Department for
Business, Energy
& Industrial Strategy

Our Ref: EN020022

Application for Development Consent (“the Application”) by AQUIND Limited (“the Applicant”) for an Order granting Development Consent for the proposed AQUIND Interconnector (“the AQUIND Interconnector project”)

REQUEST FOR INFORMATION

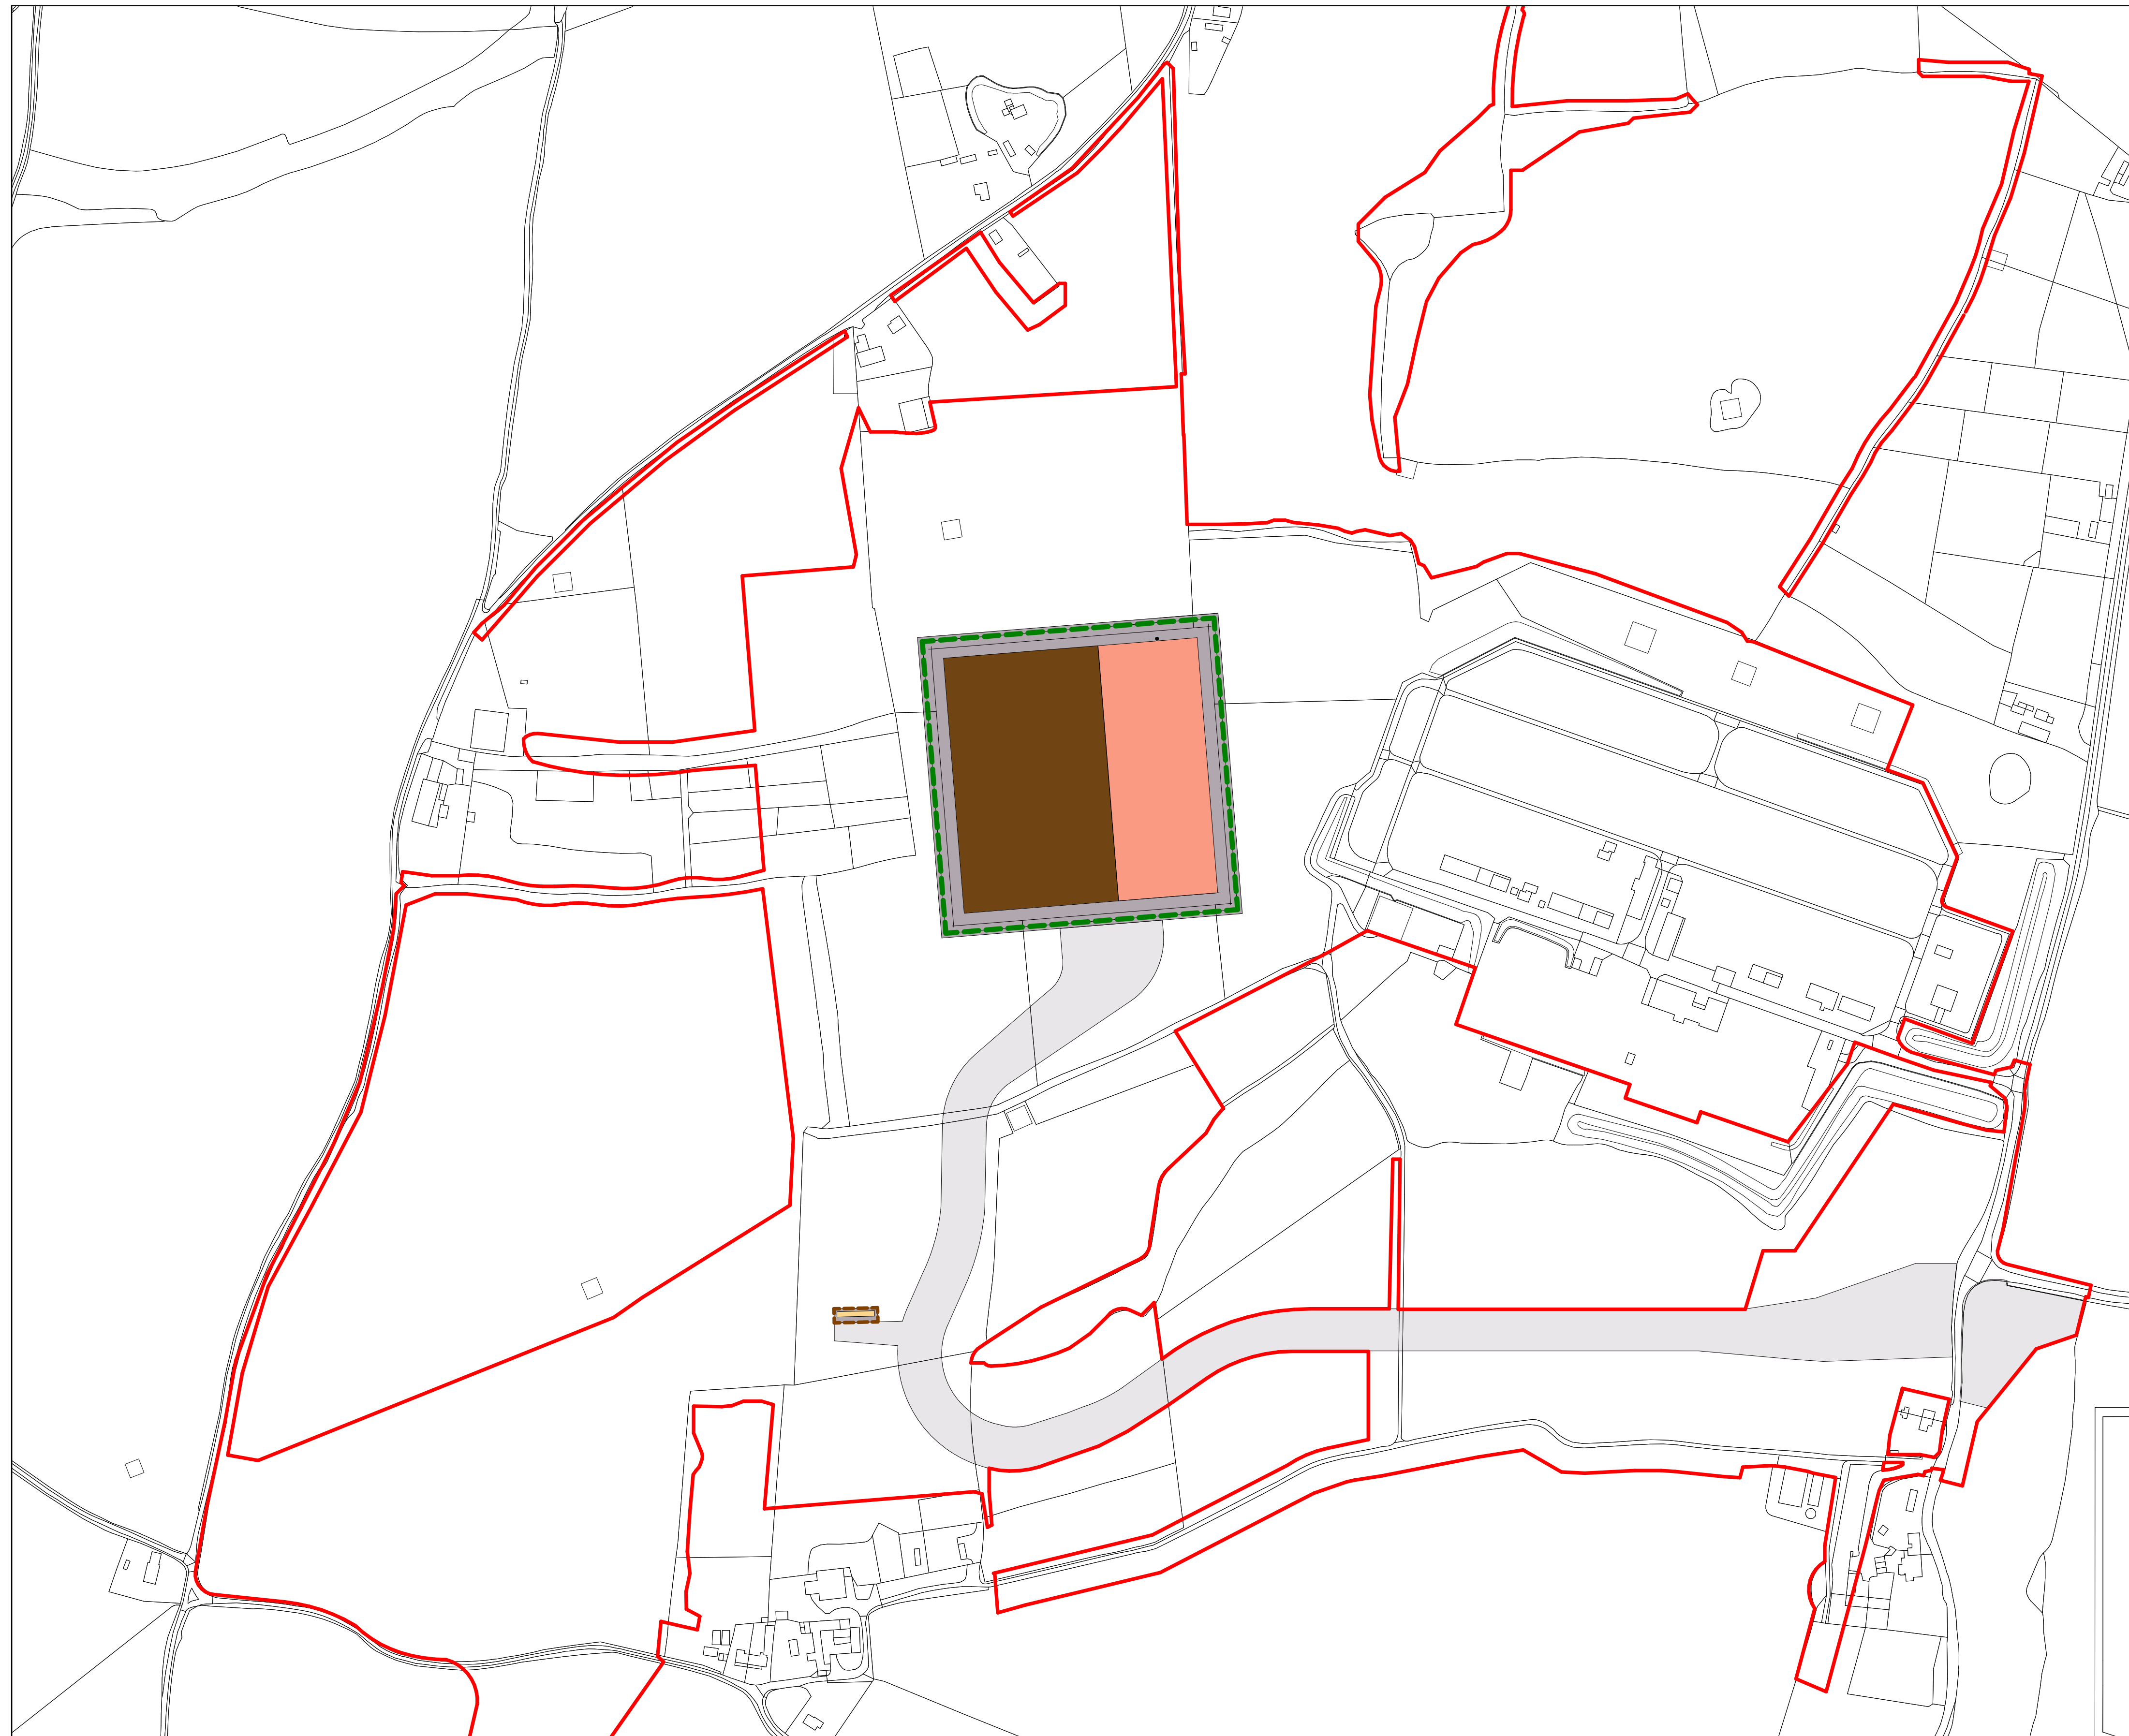
- Justification for the extent of compulsory acquisition powers sought at the plots of land associated with the commercial telecommunications buildings on the site of the converter station. The Secretary of State notes that the Applicant has advised that these buildings would not be required should the equipment required for commercial telecommunications be removed. The Applicant should confirm the reasons as to why the full extent of land will still be required if those telecommunications buildings are removed from the development consent order.

EN020022-2.11-PARA-Sheet1	Application document reference 2.11 Optical Regeneration Station(s) Parameter Plan Sheet 1 of 1
---------------------------	--

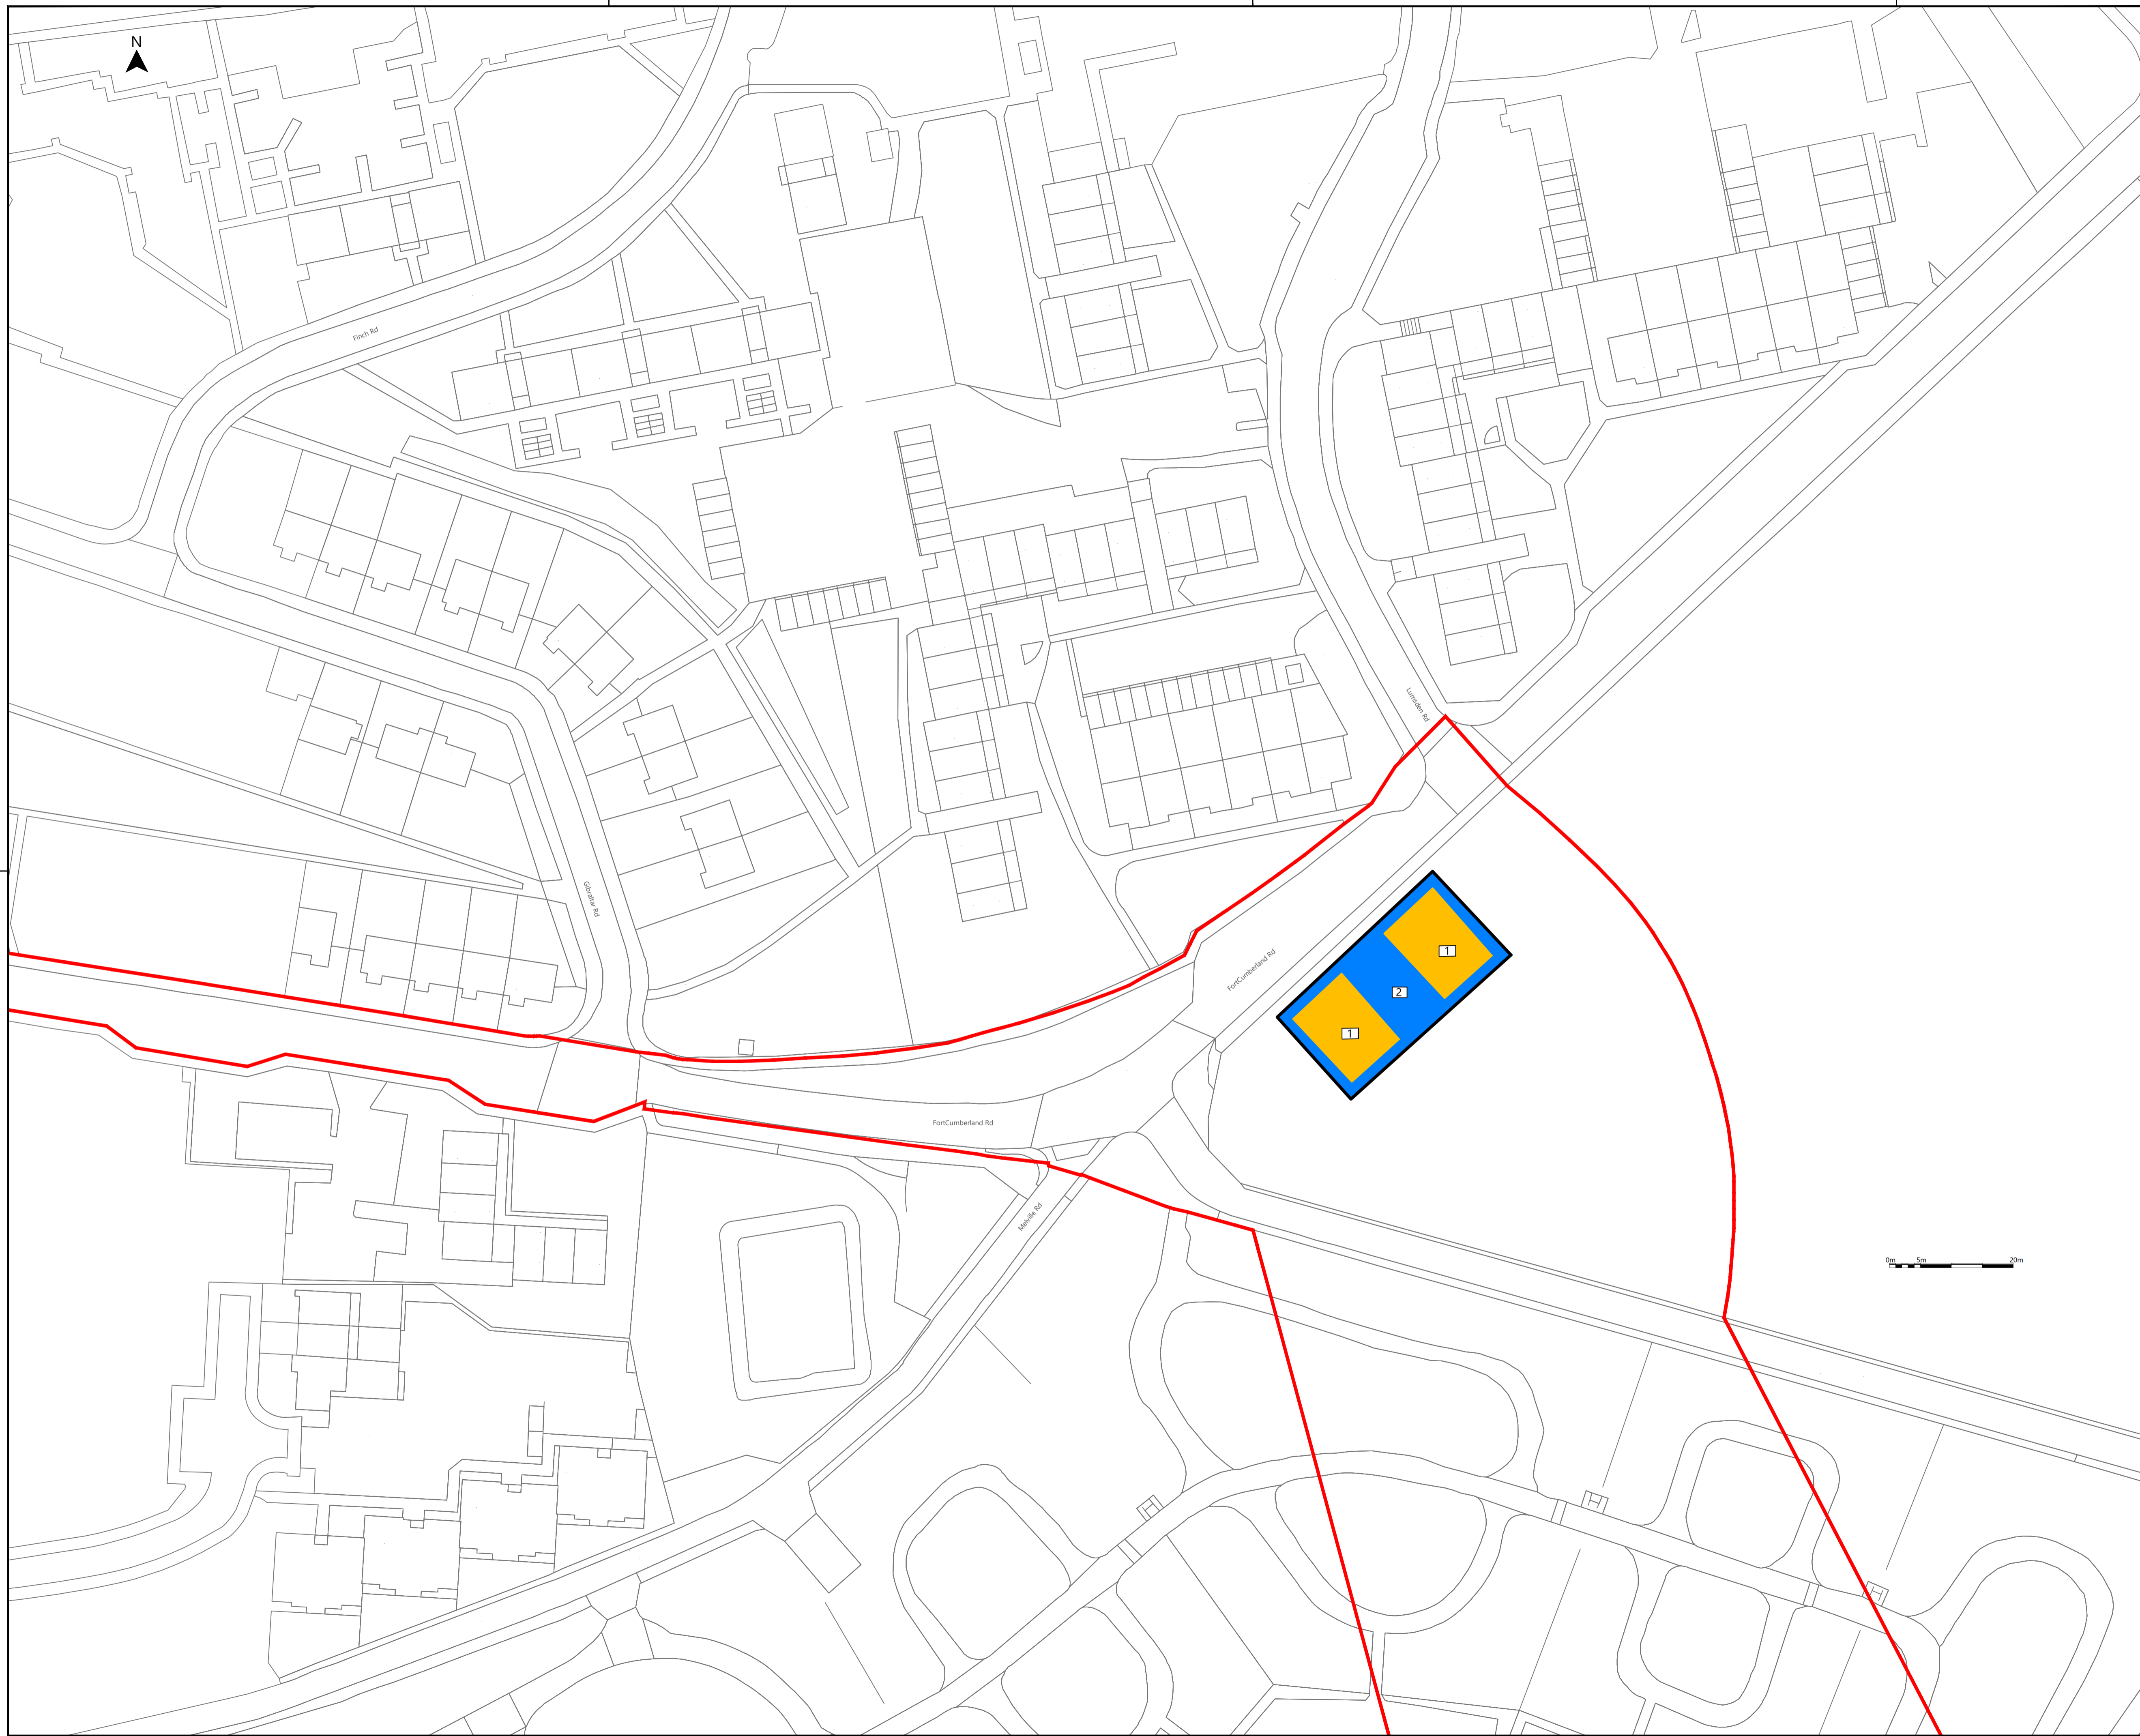
- Justification for the extent of the compulsory acquisition powers sought at the plots of land associated with the proposed optical regeneration site. This should include a revised plan that shows the land required for the optical regeneration buildings with any commercial telecommunications removed, the siting of those buildings, and any revised Order limits. In particular the Secretary of State notes that the Applicant has advised that the optical regeneration site will reduce in size by approximately two thirds should the equipment required for commercial telecommunications be removed. The Applicant should therefore confirm how many (if any) optical regeneration stations are required in those circumstances. The Applicant should also confirm if the impact on the Fort Cumberland car park is anticipated to change if the commercial telecommunications elements of the proposal were removed.
